Our Ref: AW/344/14/HH
Your Ref:

Application for Planning Permission for Works or Extension to a Dwelling

Development Increase existing single storey side extension, clad external elevations with insulation & render, remove existing clay tiled roof & recover with Welsh slates, 3 velux windows within the north facing front roof elevation, reconstruction of first floor balcony, new external steps at rear of side extension gable roof extension to existing first floor living room & construct external garden swimming pool. This application affects the character and appearance of the Craigweil House Conservation Area.

Location 68 The Drive Bognor Regis

Site Plan shows area bounded by: 490957.2893,96126.2893 491098.7107,96267.7107 (at a scale of 1:1250) The representation of a road, track or path is no evidence of a right of way. The representation of features as lines is no evidence of a property boundary.

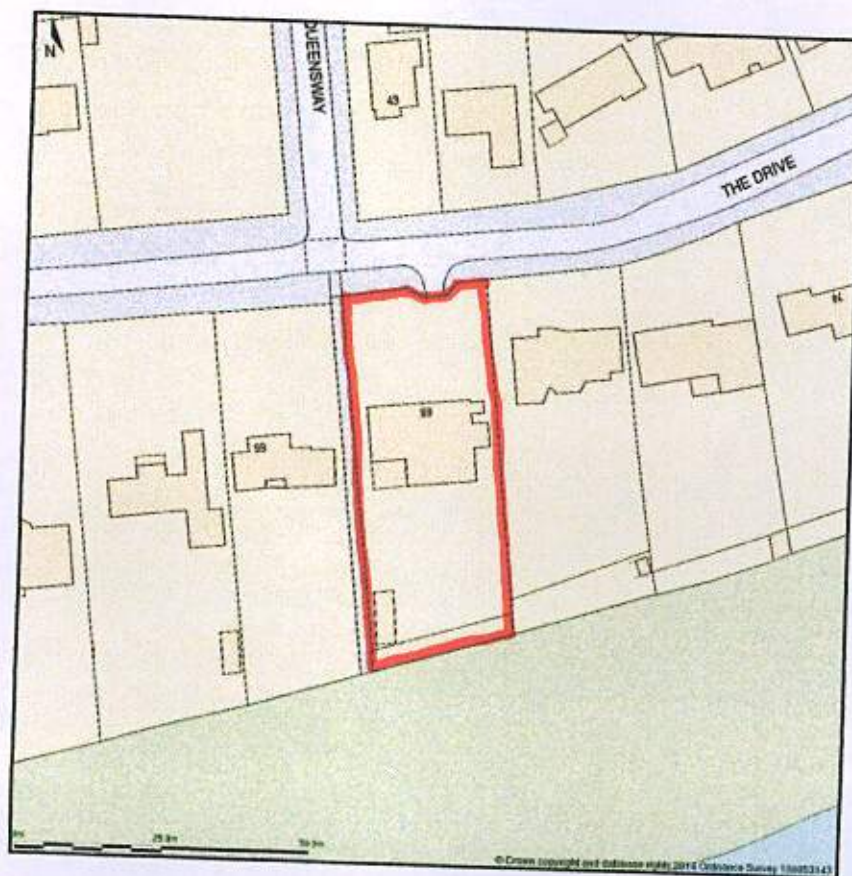
Location Plan

Please submit 1 electronic or 3 paper copies of a location plan at a scale of 1:1250 or 1:2500 for rural areas. Further details of what must be included on the plan can be found in the National Validation Requirements. Please red edge the site and provide two named roads.

The Location and Block plan do not scale correctly. Please amend accordingly.

ROOF PLAN

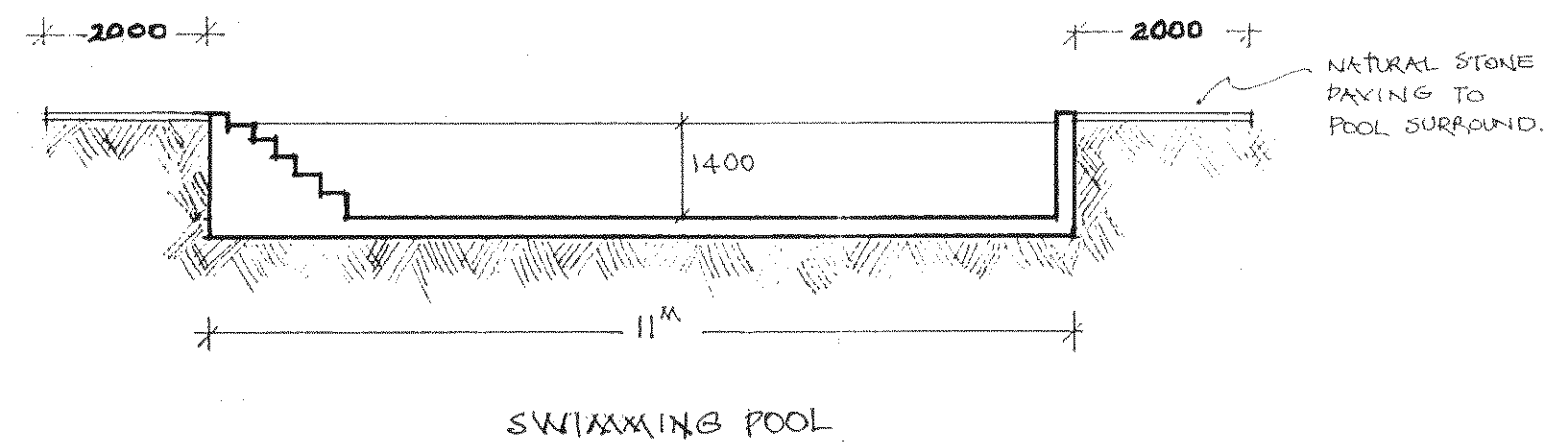
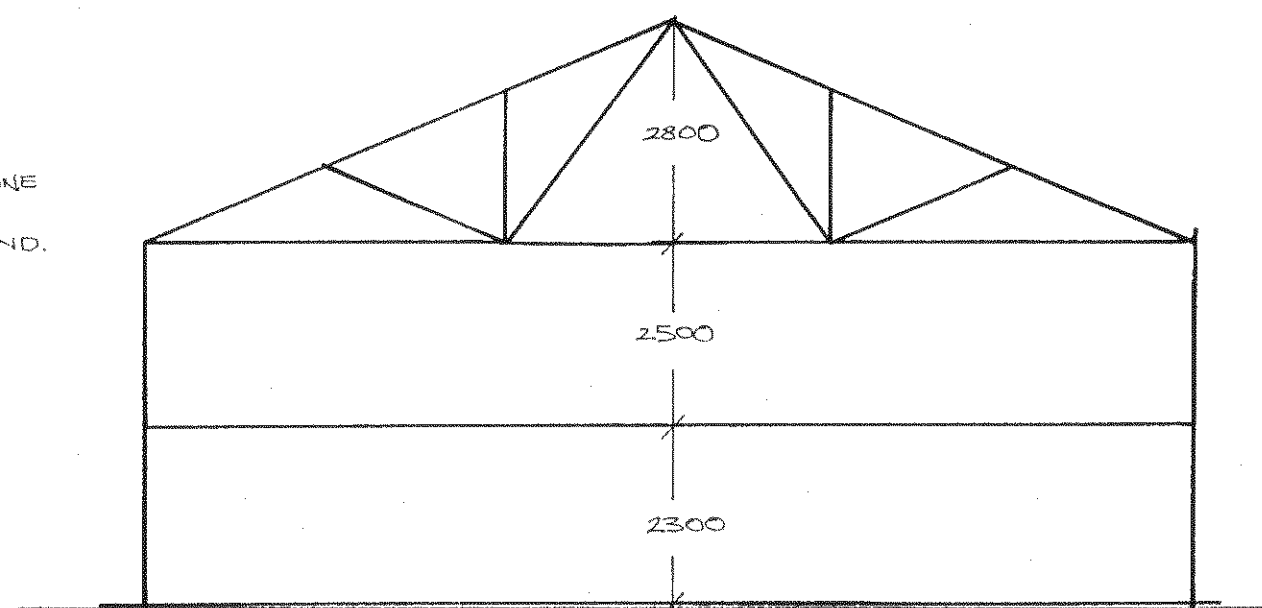
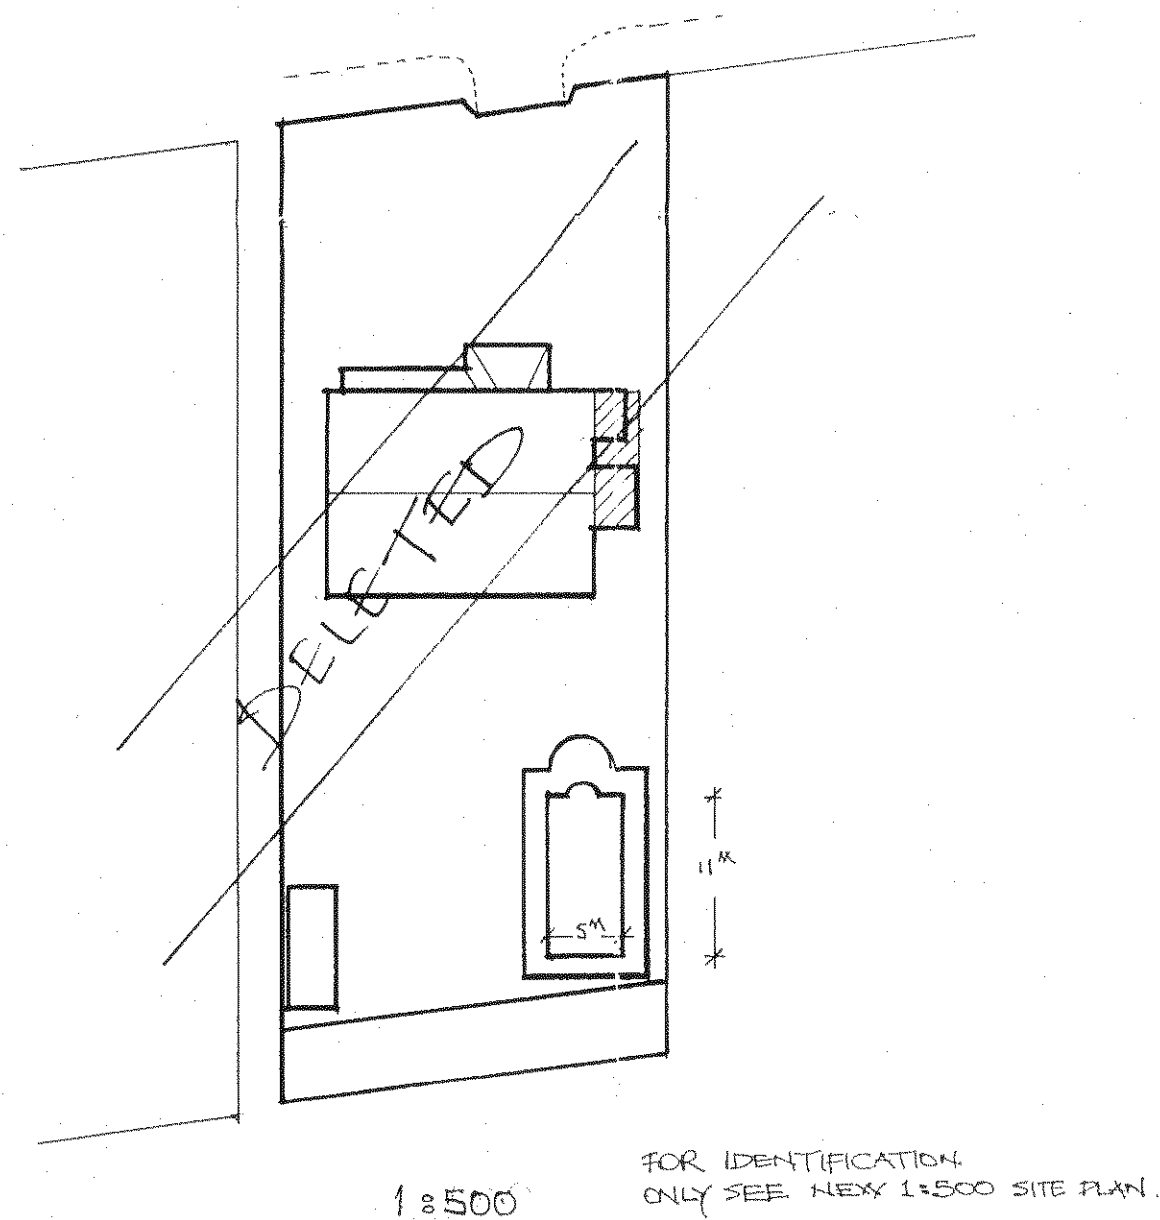
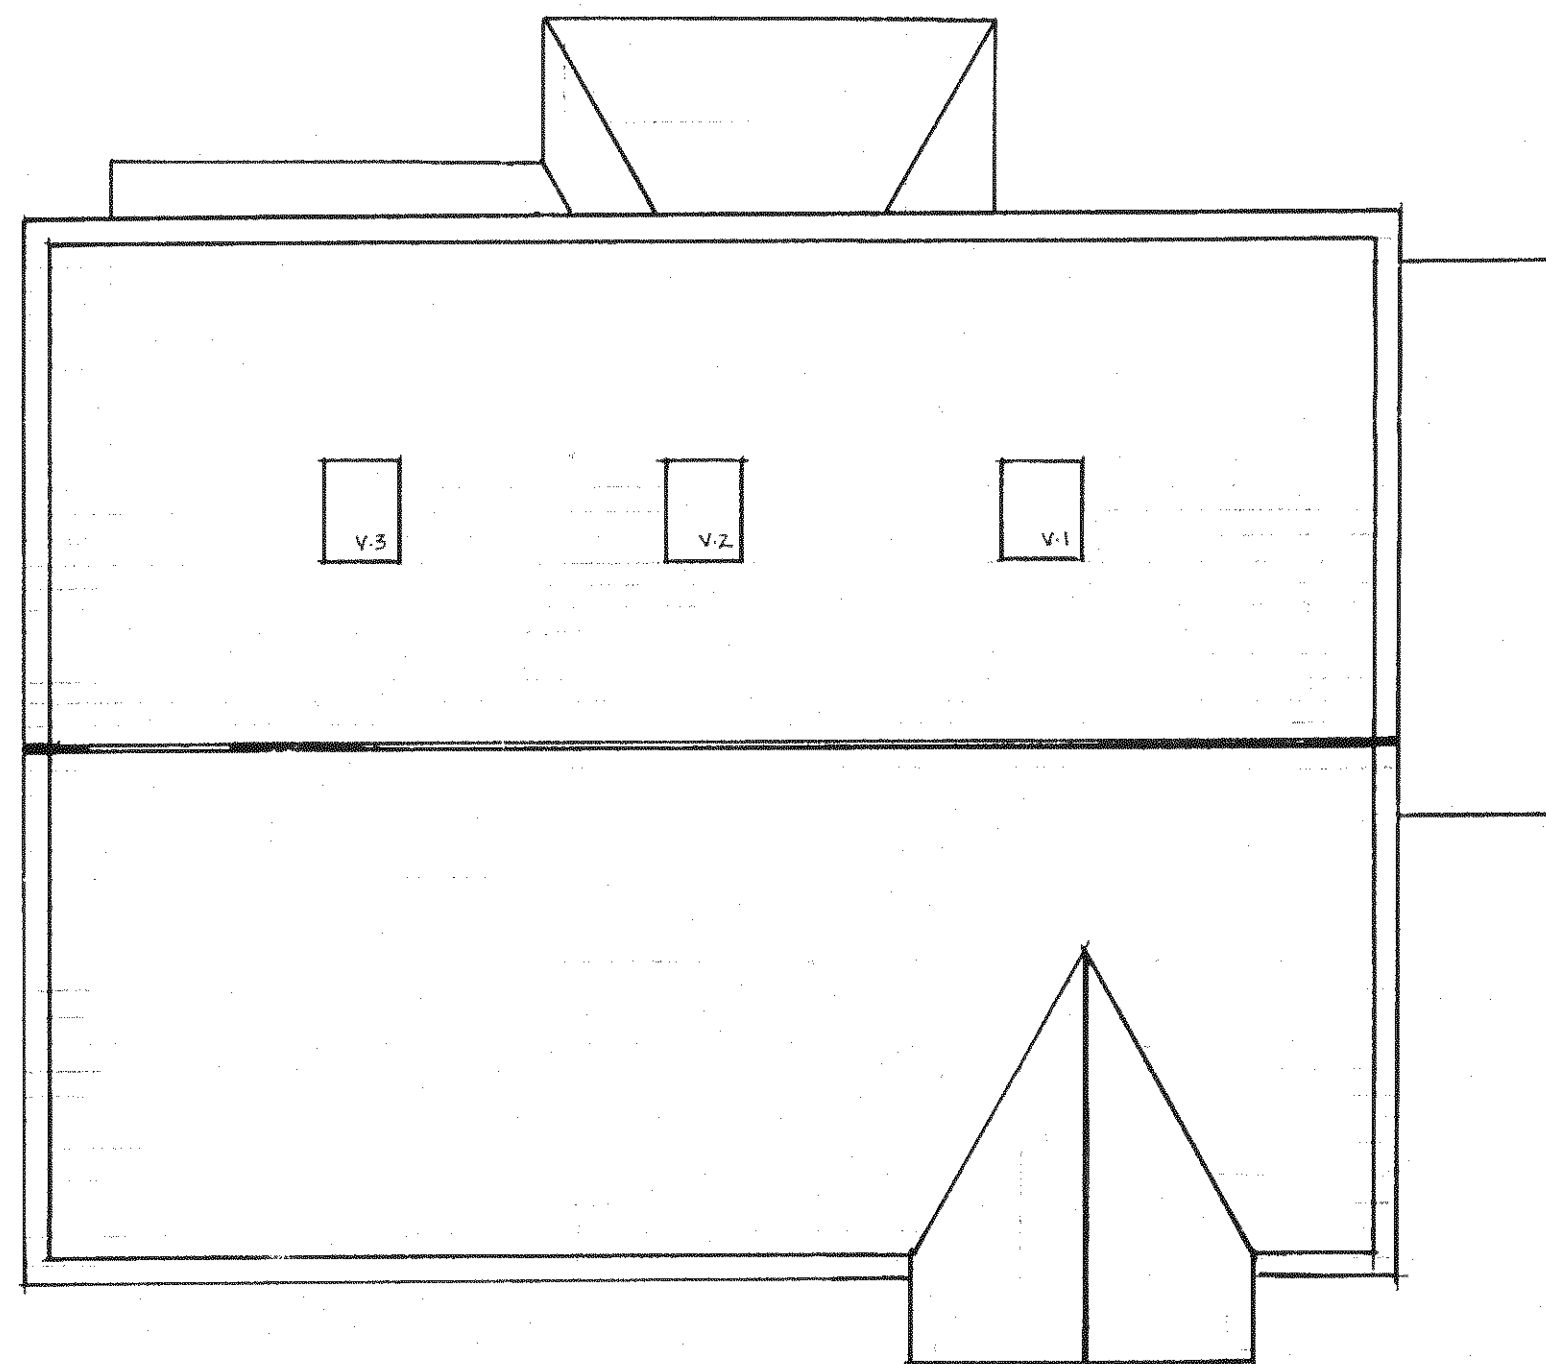
Please show the proposed velux windows on the proposed first floor plan.

WEST ELEVATION PROPOSED

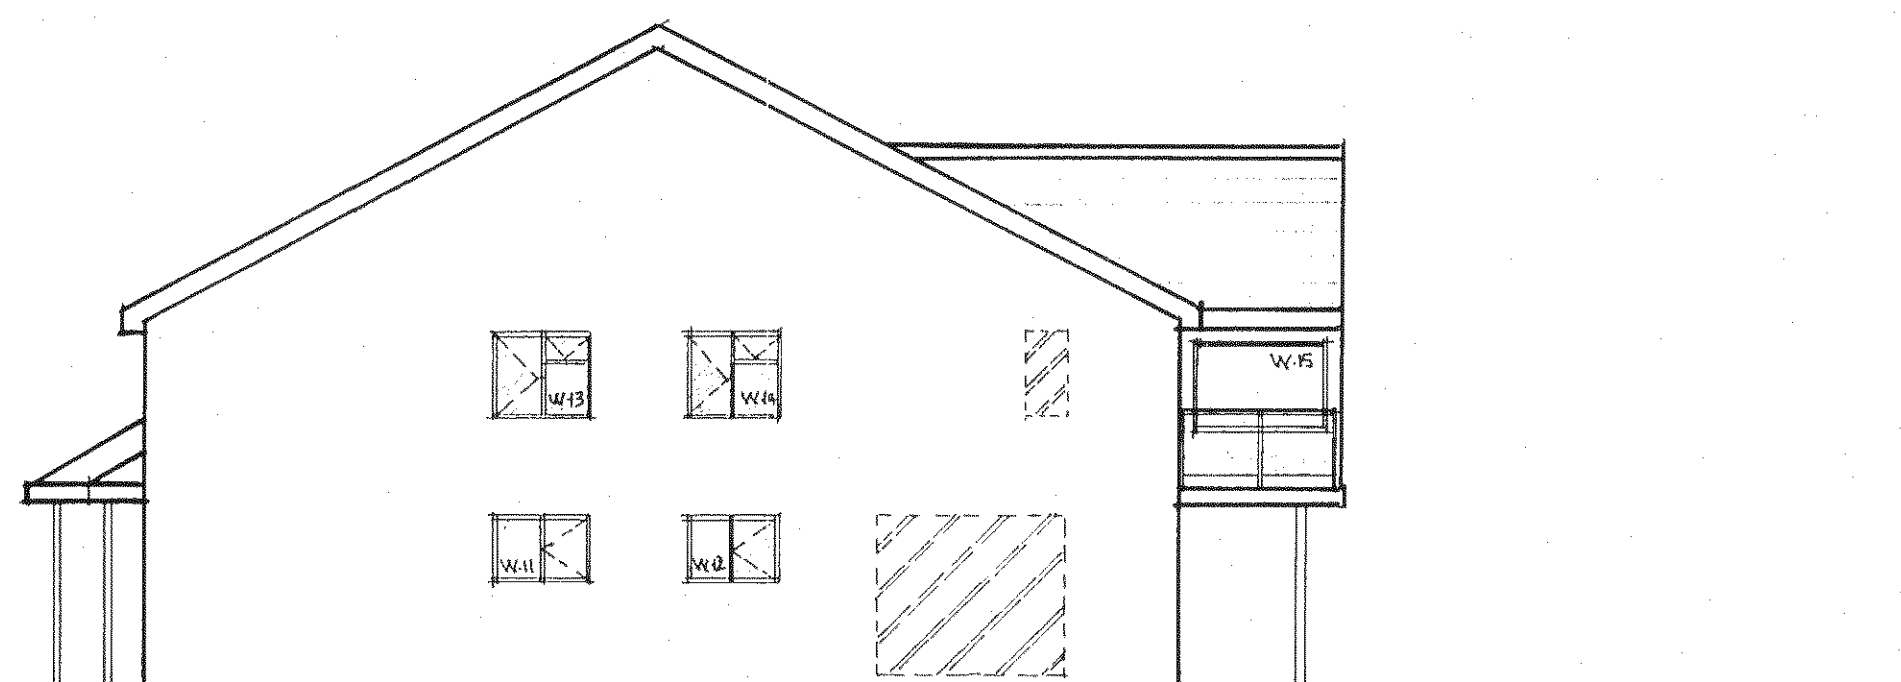
The proposed West elevation and ground floor plan do not accord. Please amend accordingly.

Block Plan shows area bounded by: 490983.0,98152.0 491073.0,98242.0 (at a scale of 1:500). The representation of a road, track or path is no evidence of a right of way. The representation of features as lines is no evidence of a property boundary.

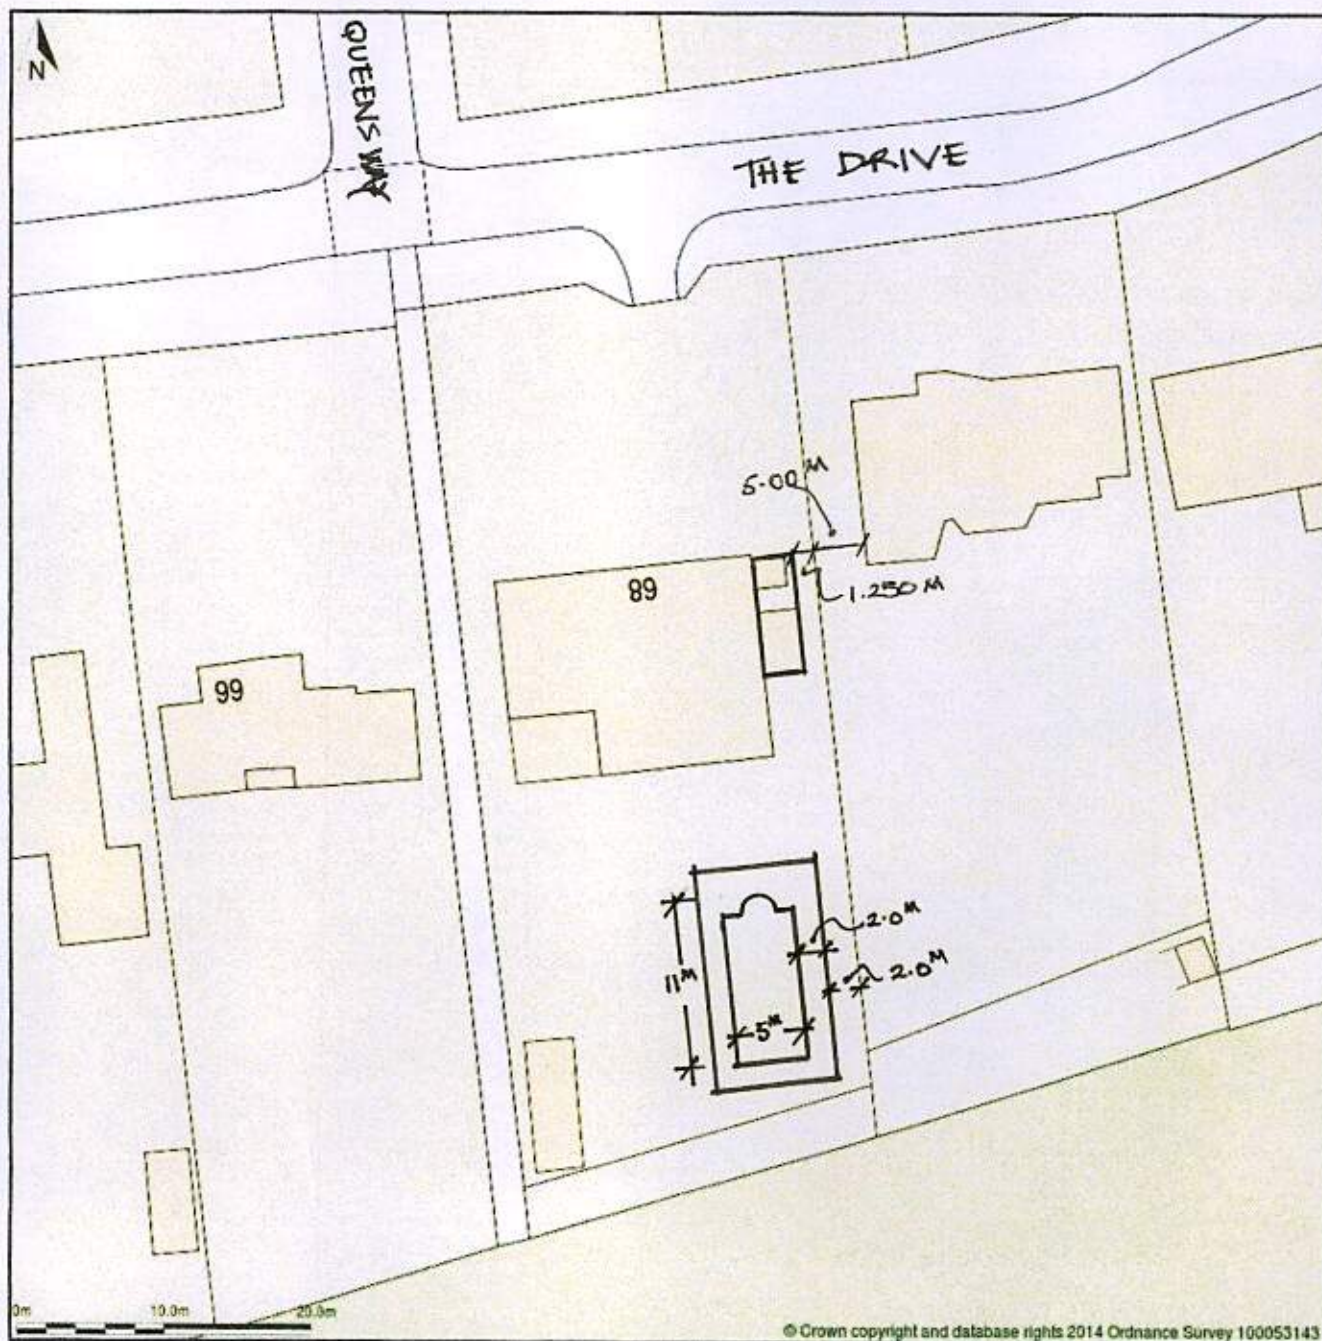
Block Plan

Please submit 1 electronic or 3 paper copies of a block/site plan at a scale of 1:500 or 1:200. Further details of what must be included on the plan can be found in the National Validation Requirements. Please provide one named road, a North point, measurements from the proposals to the site boundaries and the surrounding properties.

SOUTH ELEVATION - PROPOSED

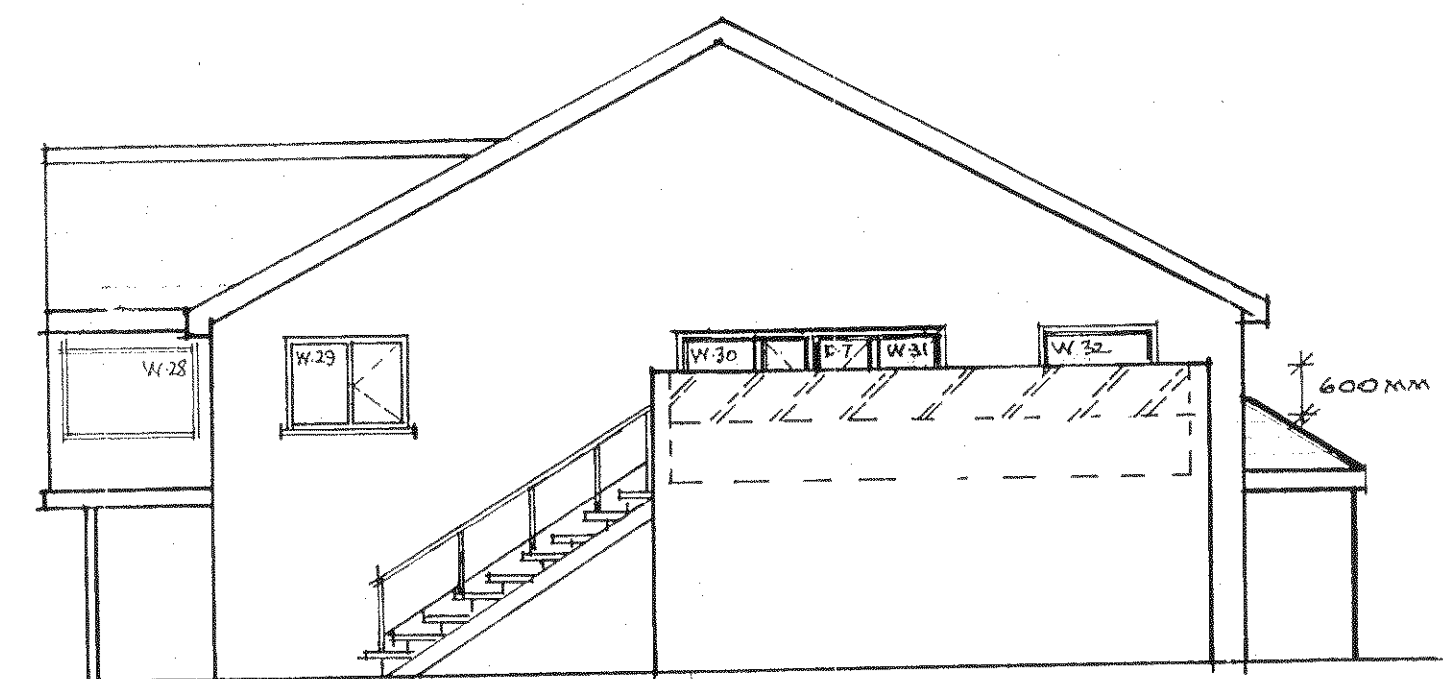
The proposed South elevation and ground floor plan do not accord. Please amend accordingly.

The proposed East elevation and first floor plan do not accord. Please amend accordingly.
